Alan Varela, Director

July 25, 2024

**Re: Alvarado Roofing Headquarters at 4015 Hawkins St. NE  
Erosion and Sediment Control Plan  
Engineer's Stamp Date 5/20/24 (D17E008)**

Sheet Title:
LANDSCAPE PLAN

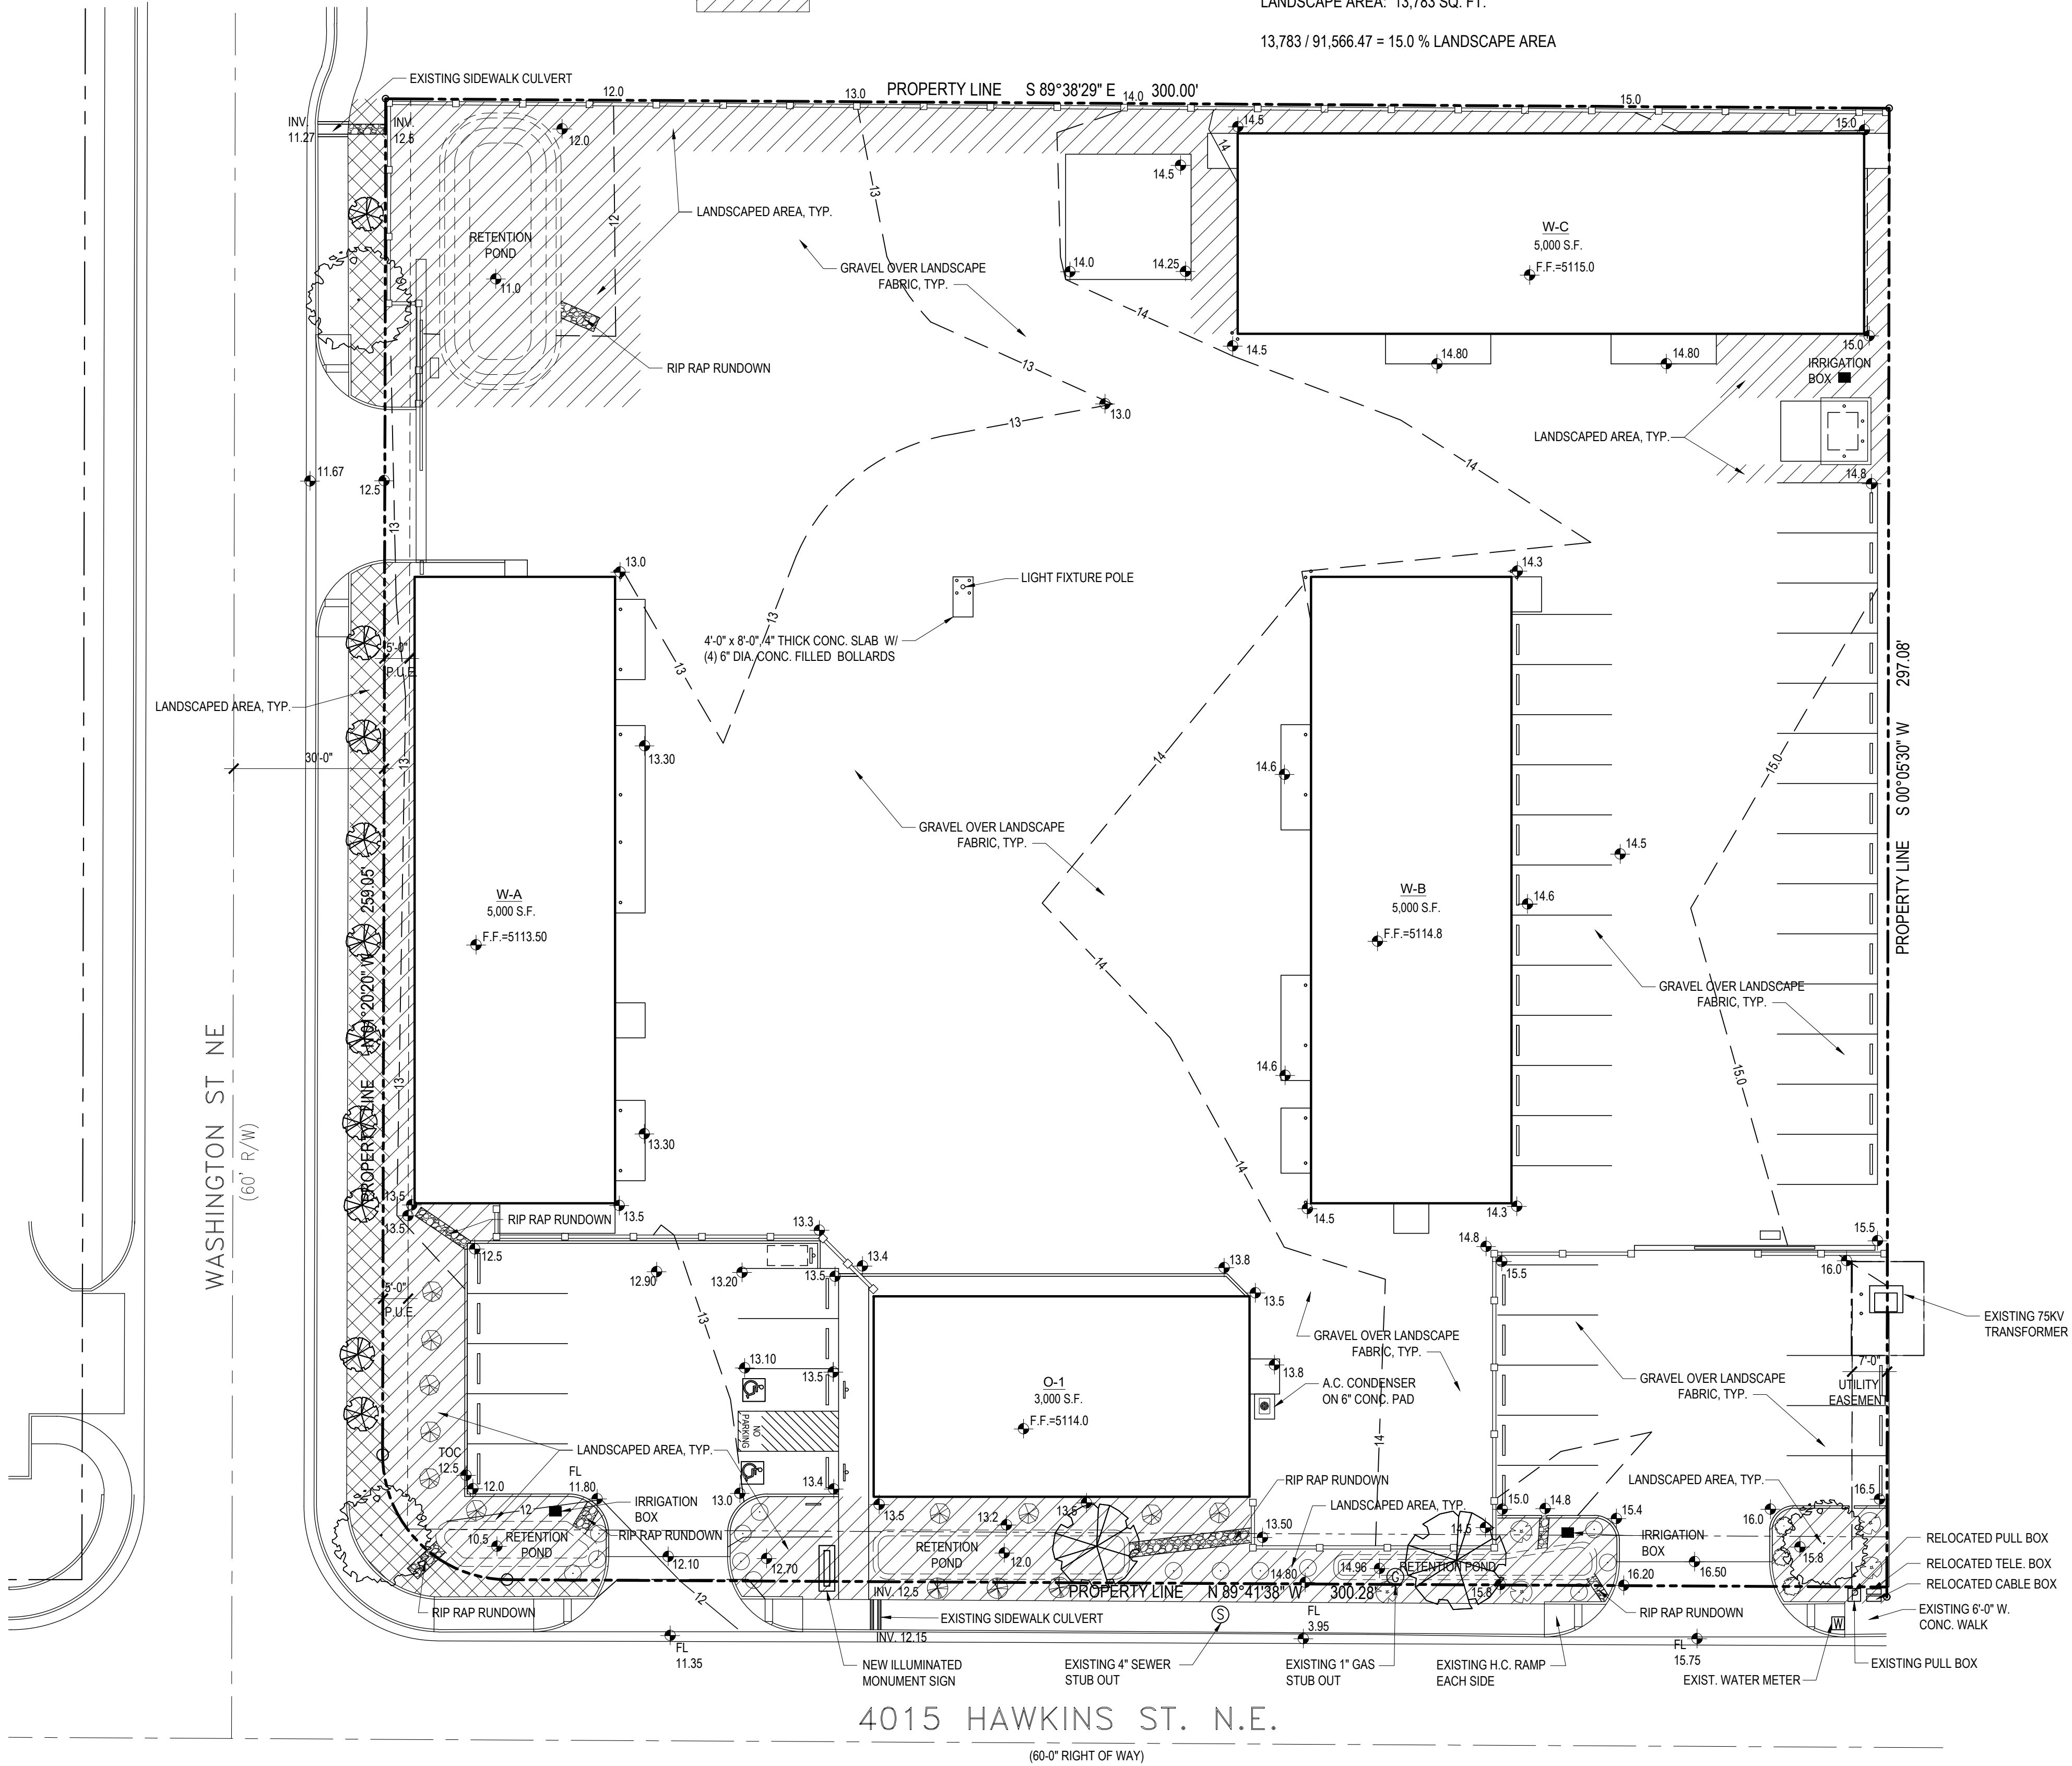
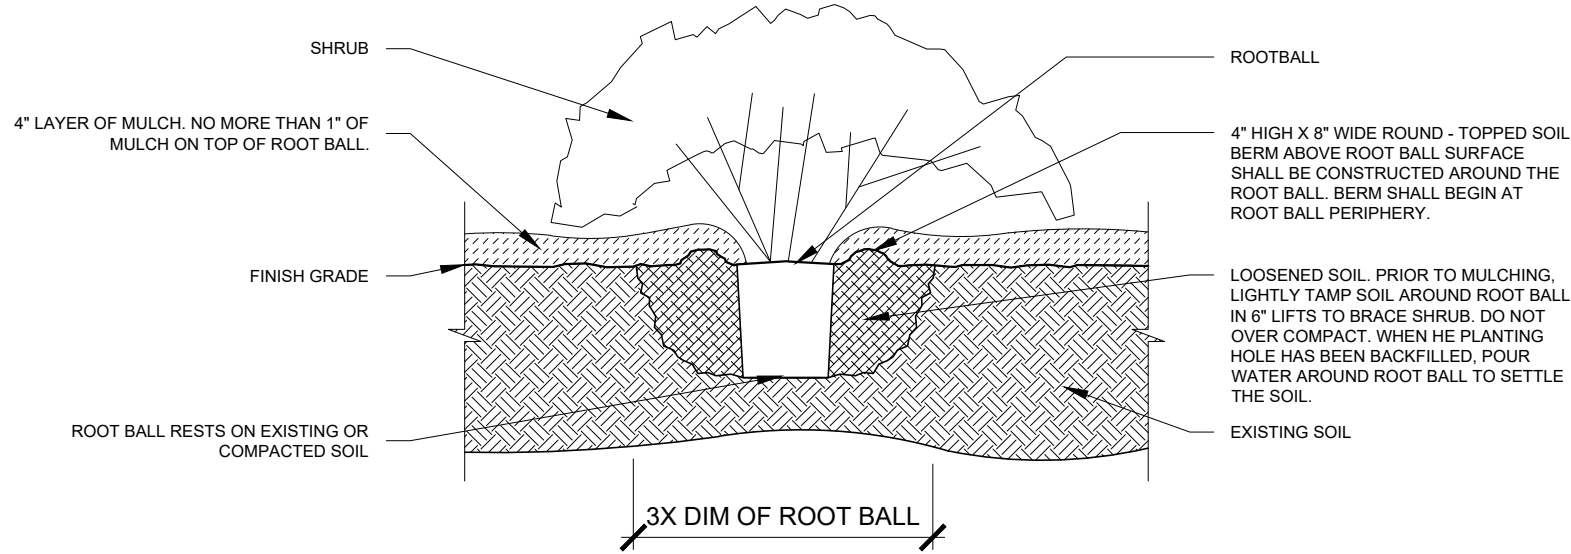
2. This ESC Plan submittal consists of a 32-page PDF file with 13 half-size plan sheets, one of which is the Landscape Plan, which should not be included as one of the ESC Plan sheets. If a "Landscape Plan" is provided to specify some or all of the final stabilization, then it should be provided on a separate sheet with the ESC Plan submittal, and it should also be included in the SWPPP. However, the rest of the SWPPP is not part of the ESC Plan submittal. Please stop submitting sheets from SWPPP as part of the ESC Plan submittal instead of putting the required ESC Plan information on half-size plan sheets. All the information required on the ESC Plan Checklist must be on half-size plan sheets as required by the drafting standards in the city's Development Process Manual (DPM) Part 4-2.
